Silverleaf Solar Farm (SSD-9358) – Environmental Impact Statement

Objective Reference: CD19/07187

Attachment 1 – Updated intersection design including Basic Left Turn (BAL)

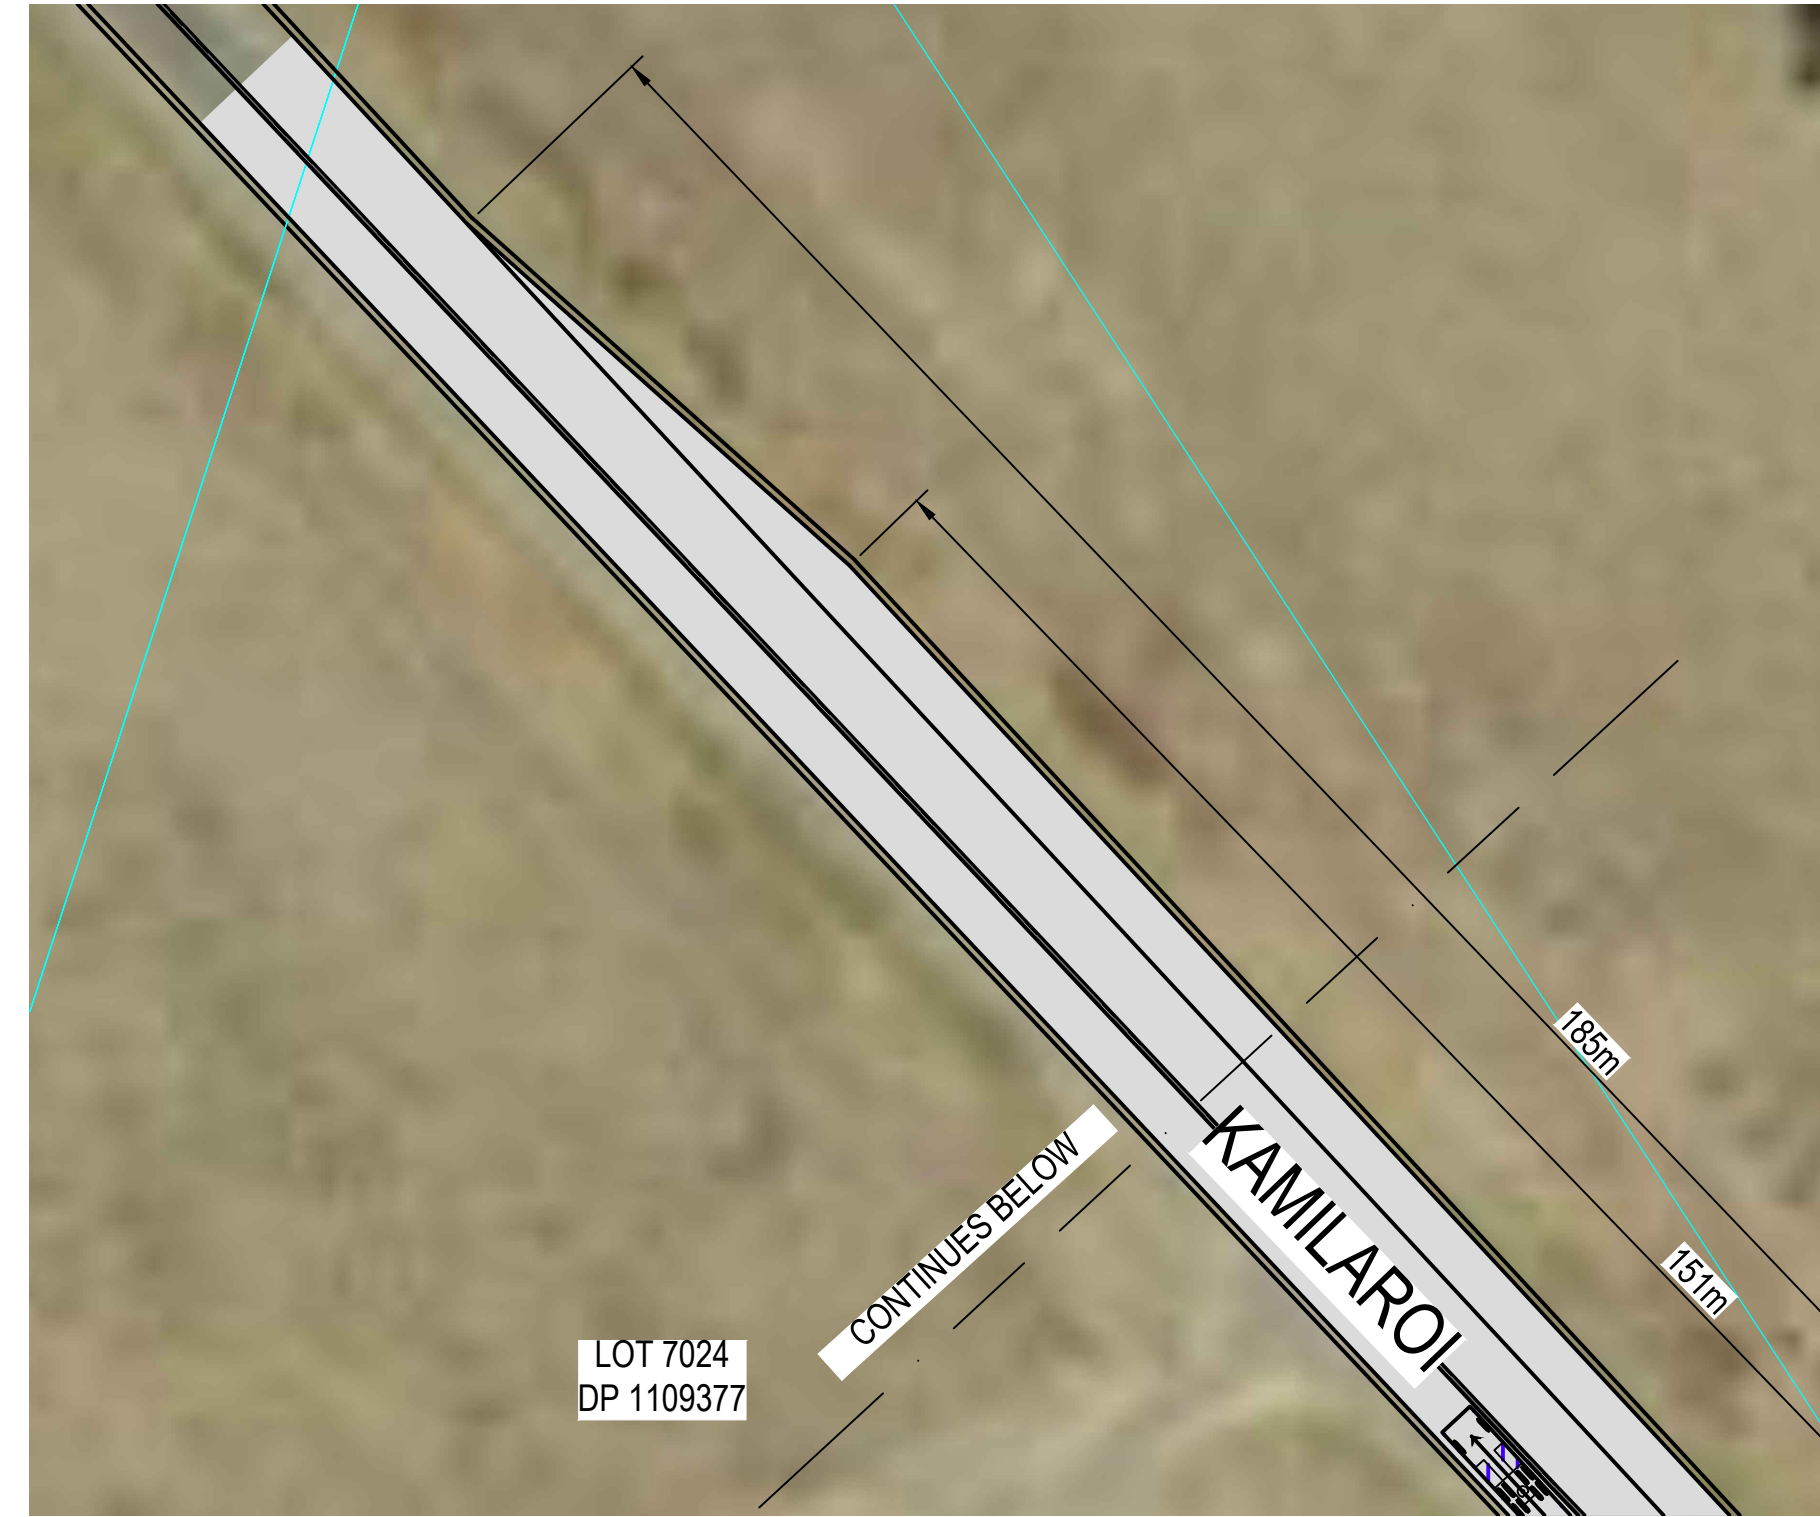
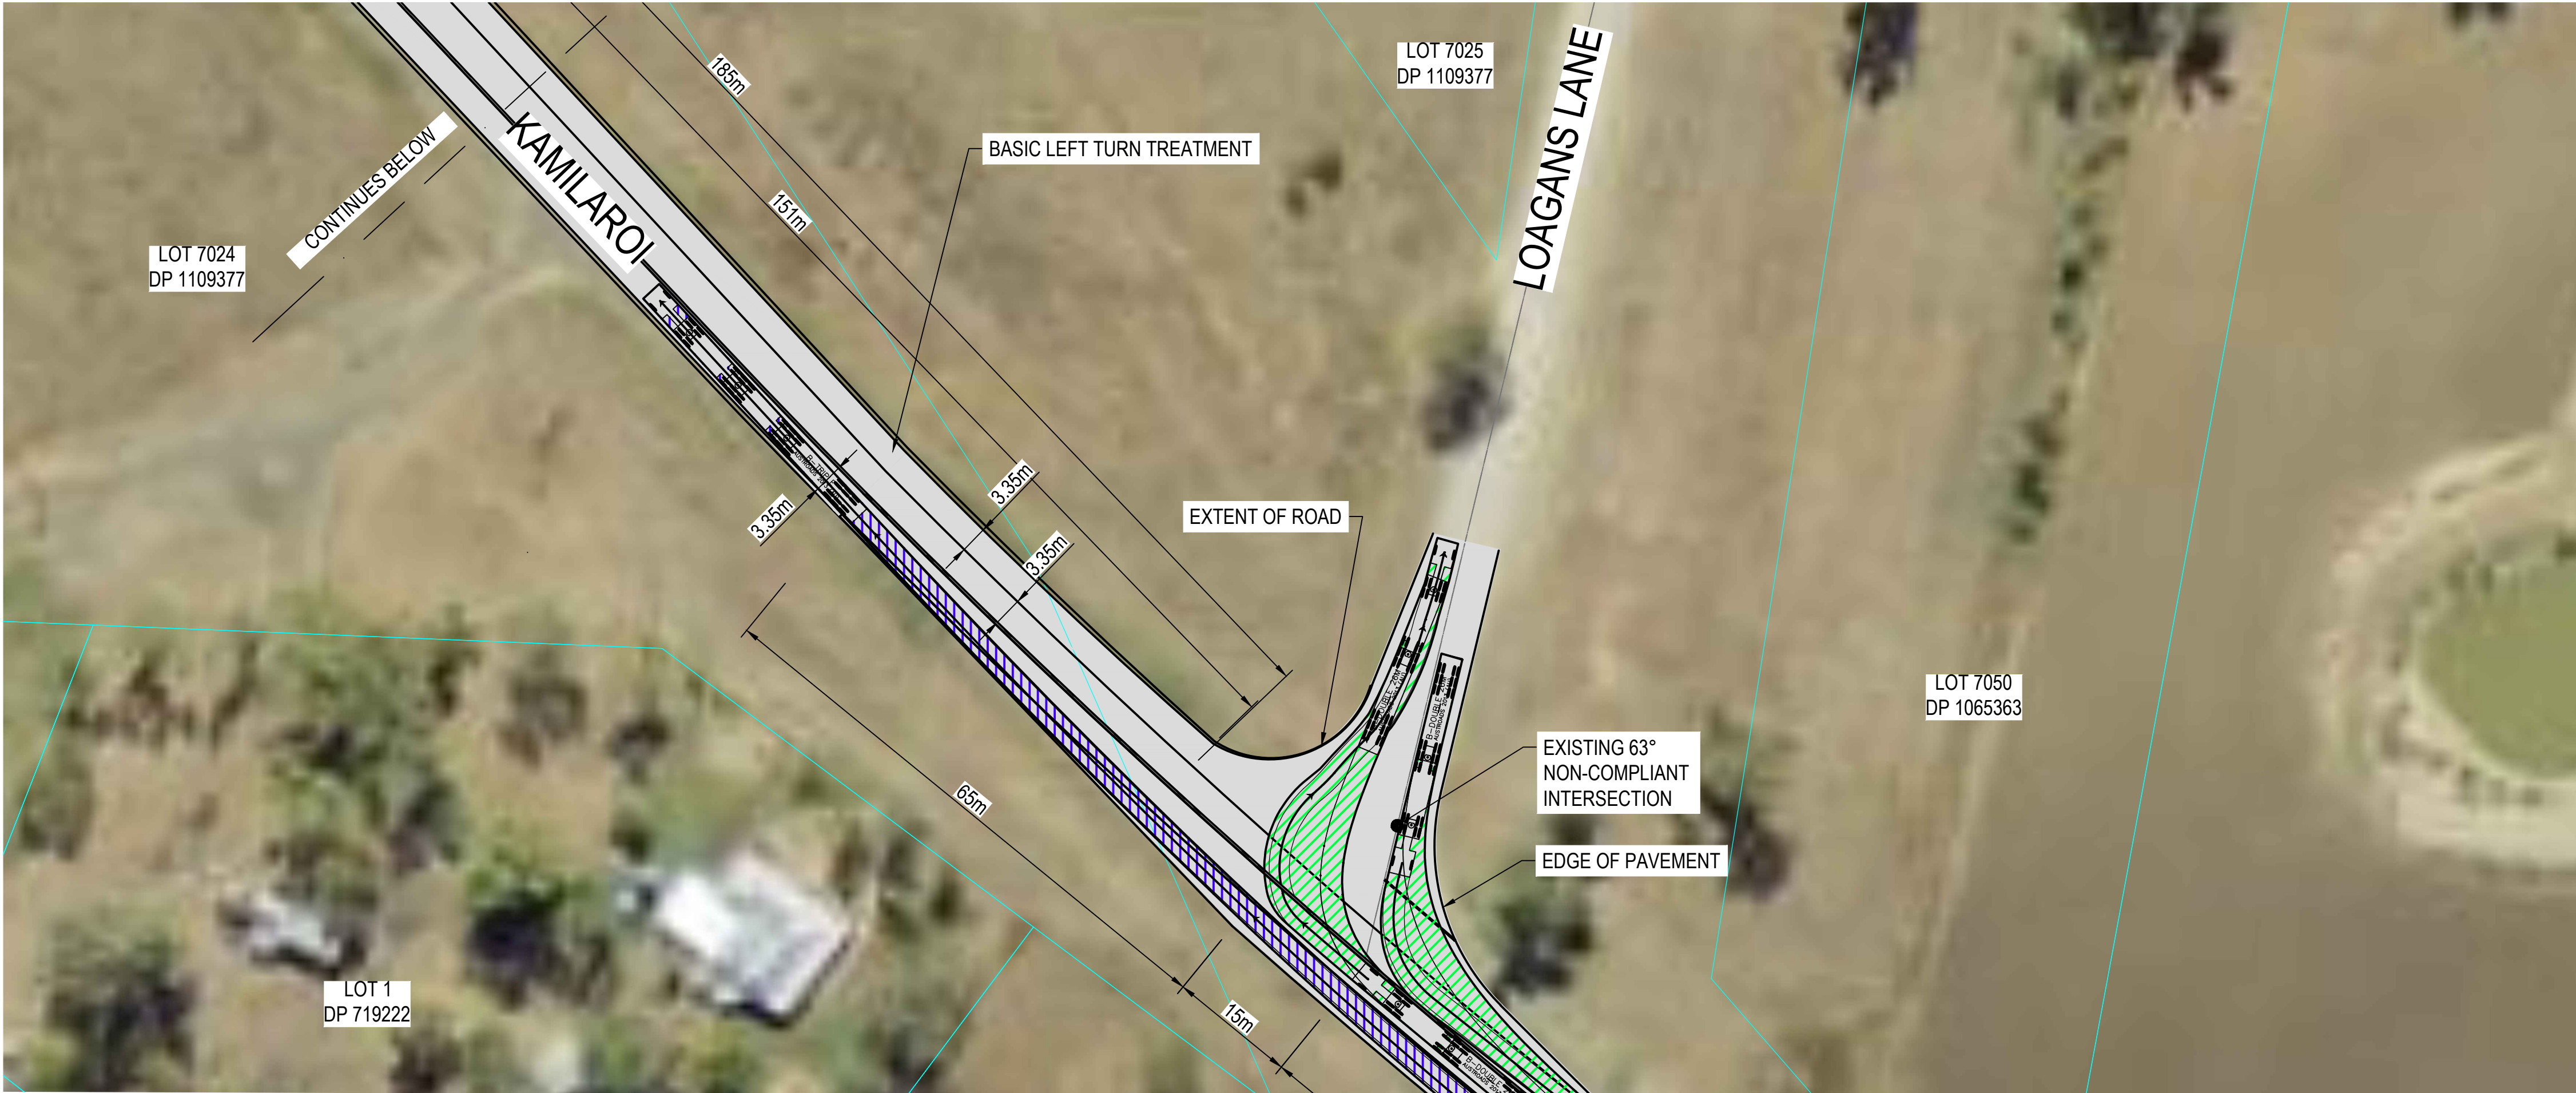
The Environmental Impact Statement (EIS) states there may be requirements for additional traffic measures to mitigate road safety risks, including those associated with public transport such as school bus stops. It is noted that these requirements will be identified in consultation with Roads and Maritime Services (Roads and Maritime) and Narrabri Shire Council (NSC) and could potentially involve a reduction in speed limits on the Kamilaroi Highway near the Logans Lane intersection. Any changes to these speed limits may impact certain school bus (Lindonfield – Kylper - Narrabri and Baan Baa – Narrabri both operated by Jeffrey Holmes) and coach routes (331, 332, 333 and 334) along the Kamilaroi Highway.

It is recommended that the Traffic Management Plan takes into account buses passing along the Kamilaroi Highway during the construction of the new intersection.

Bus operators should also be consulted with and informed of any resulting safety measures implemented, such as the reduction of speed limits, to ensure minimal impact on bus services.
